## NSW RURAL FIRE SERVICE

Your reference: SSD 9504  
Our reference: D18/7040  
DA19021117314 BB

### State Significant Development Application (SSD 9504) – West Wyalong Solar Farm

Figure 1 Bushfire Analysis

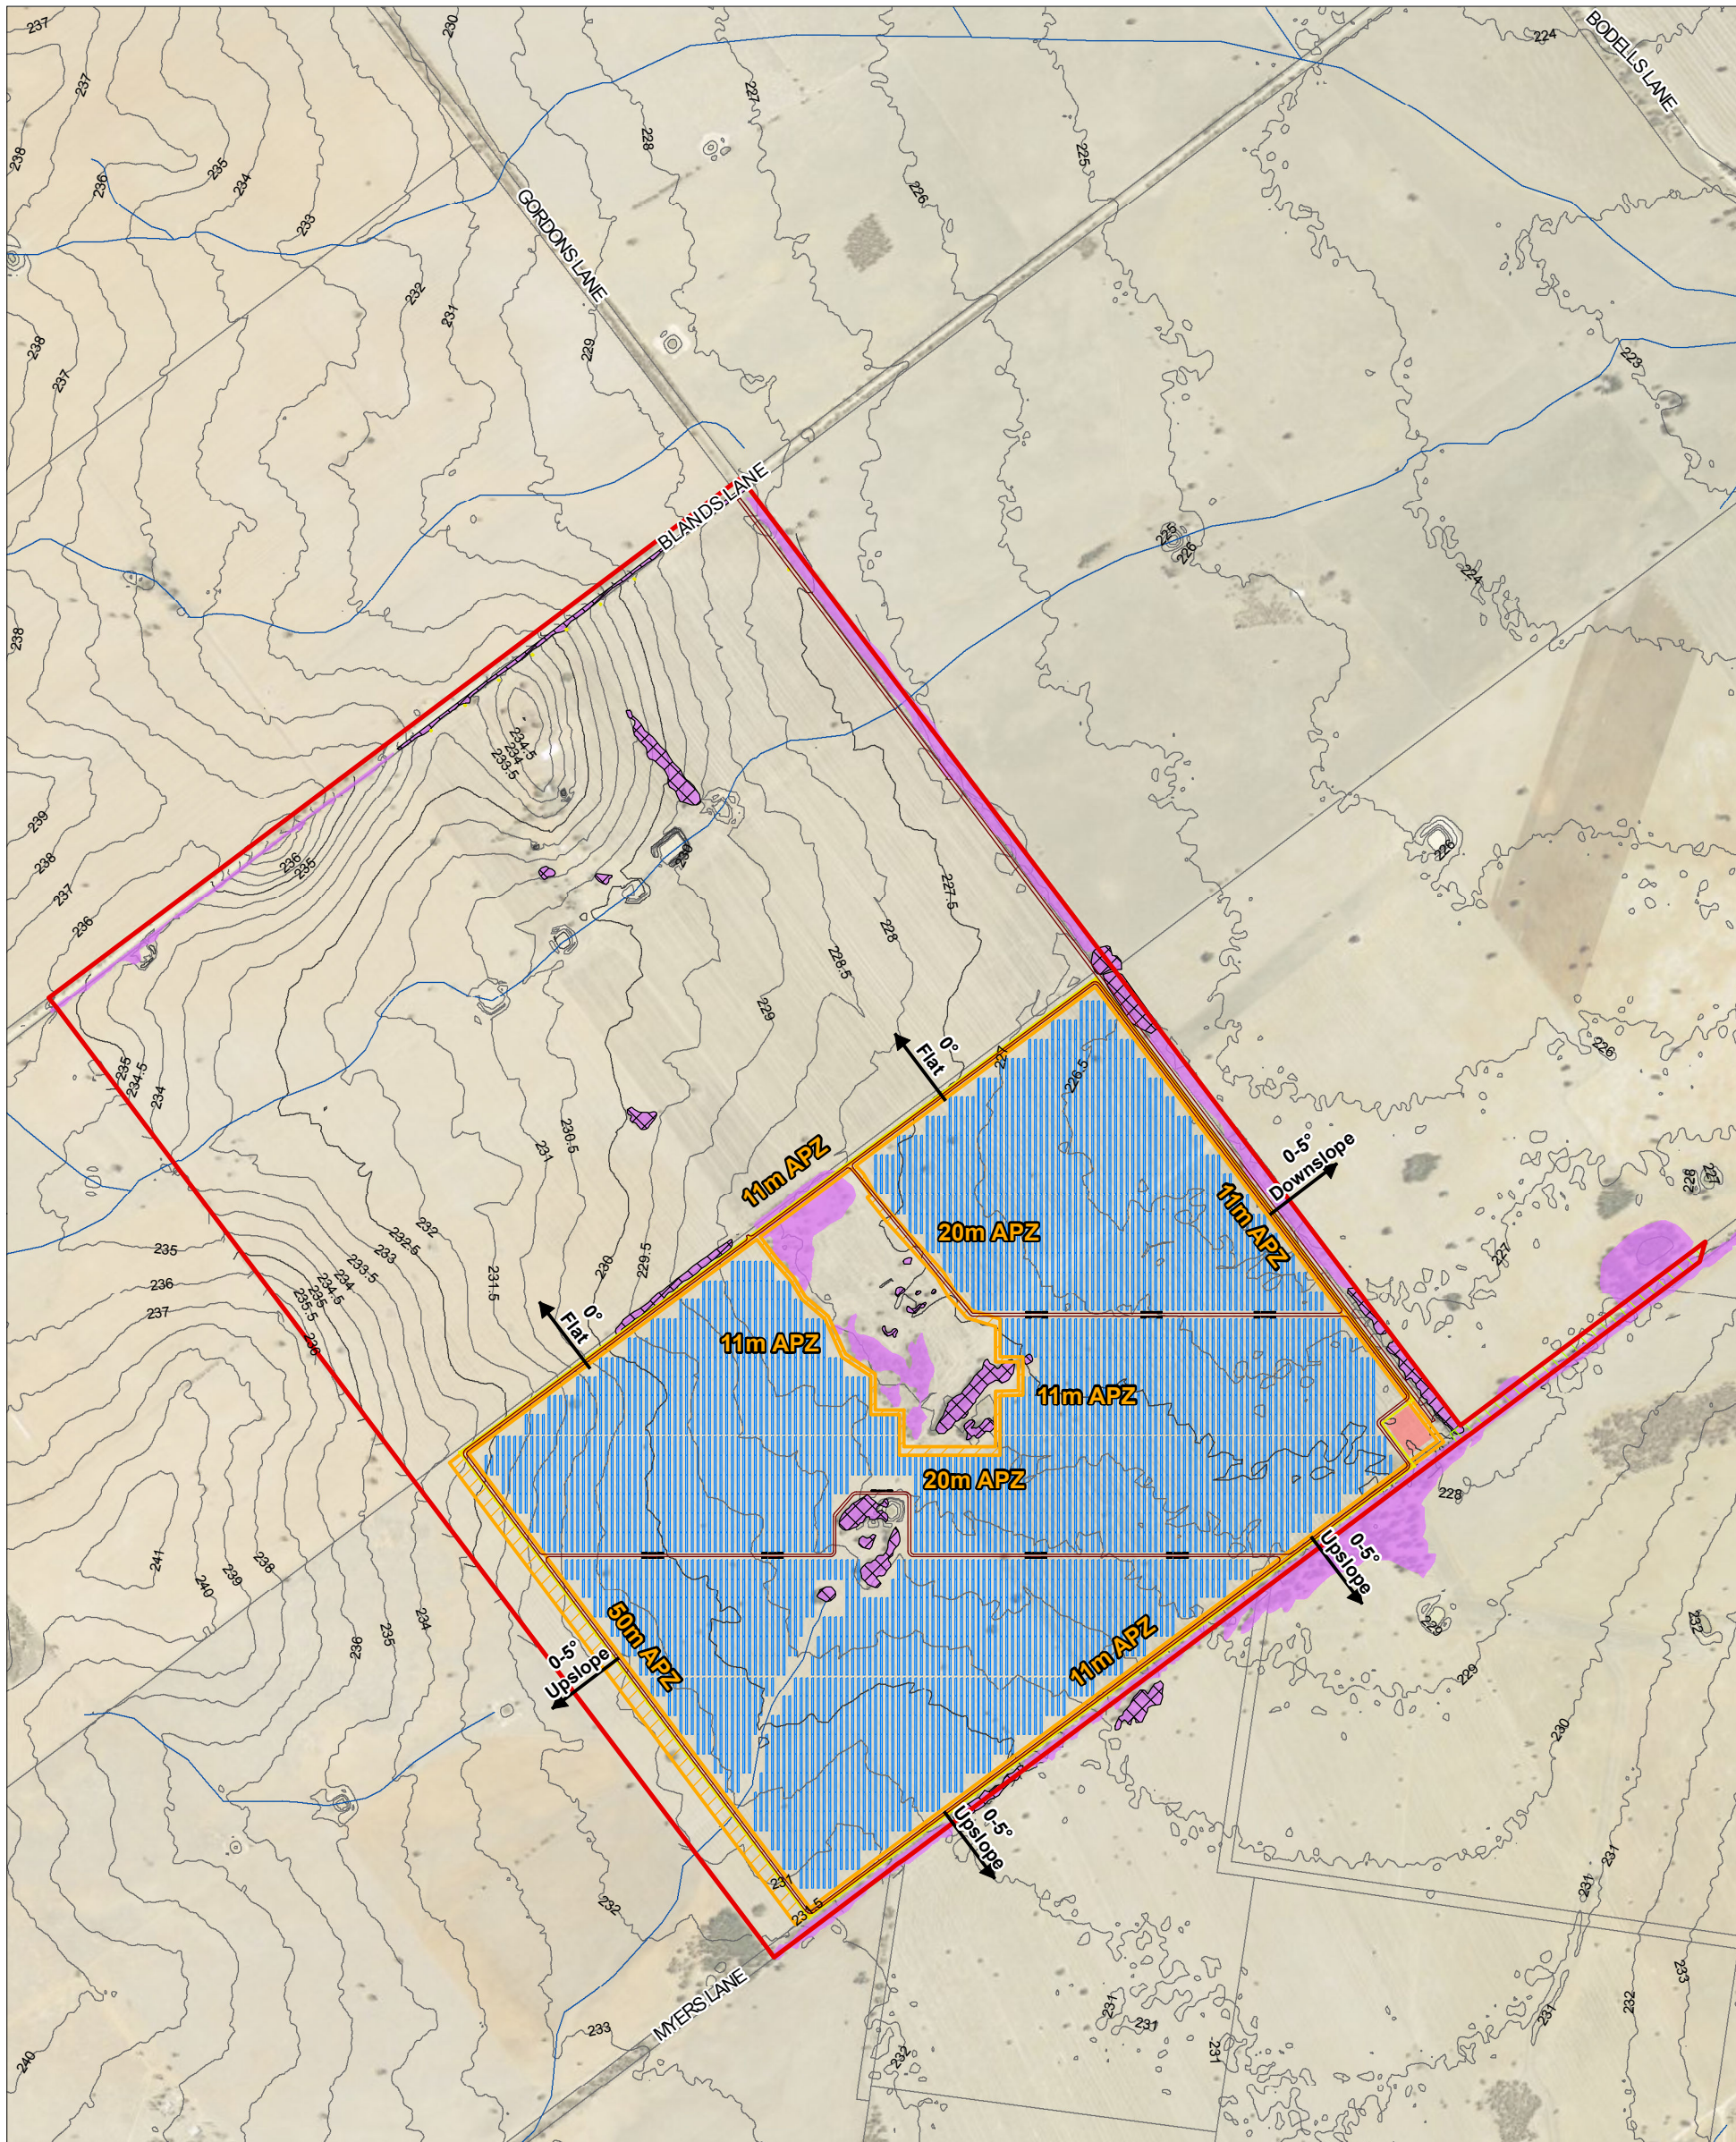
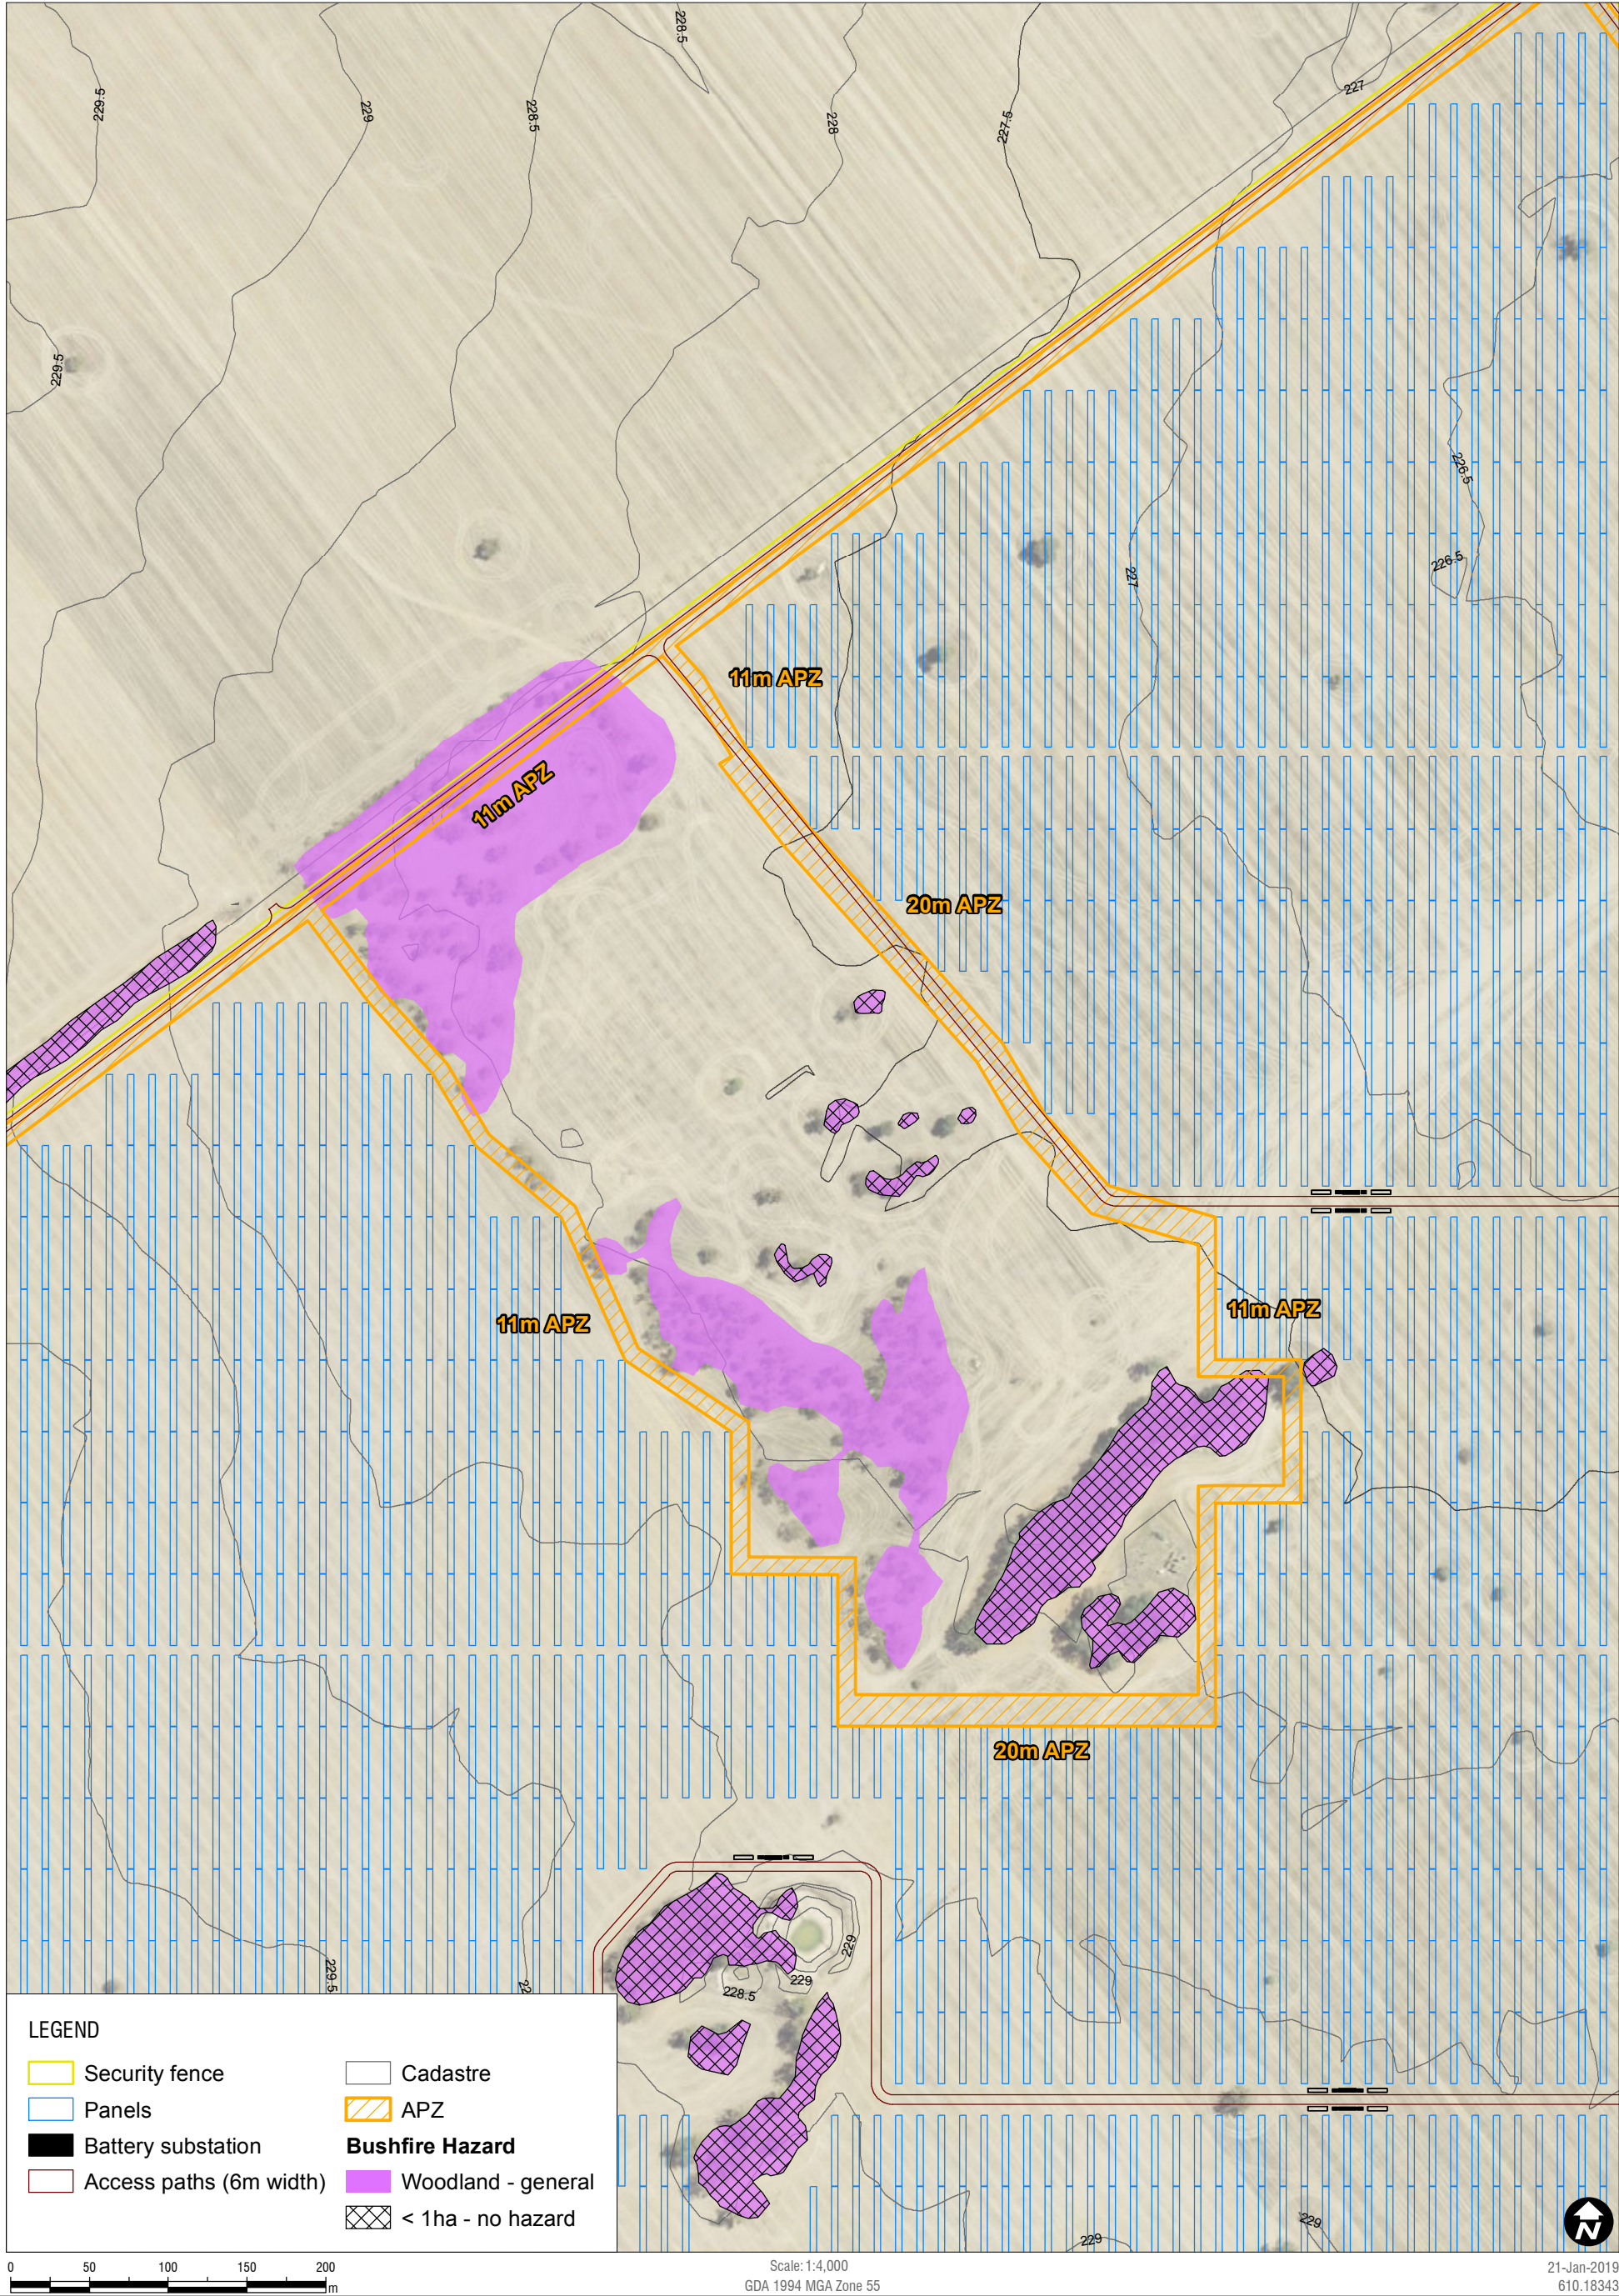
1. The proposed development shall comply with all the bush fire safeguards and mitigation measures set out in Section 5 of the Bush Fire and Fire Response Assessment report prepared by SLR Consulting Australia Pty Ltd (Ref: 610.18343-M01-v4.0 - WWSF Bushfire, dated 21 January 2019).

- Such additional matters as required by the NSW RFS District Office.
3. A minimum 20,000 litre water supply (tank) fitted with a 65mm Storz fitting shall be located adjoining the internal property access road within the required asset protection zone.
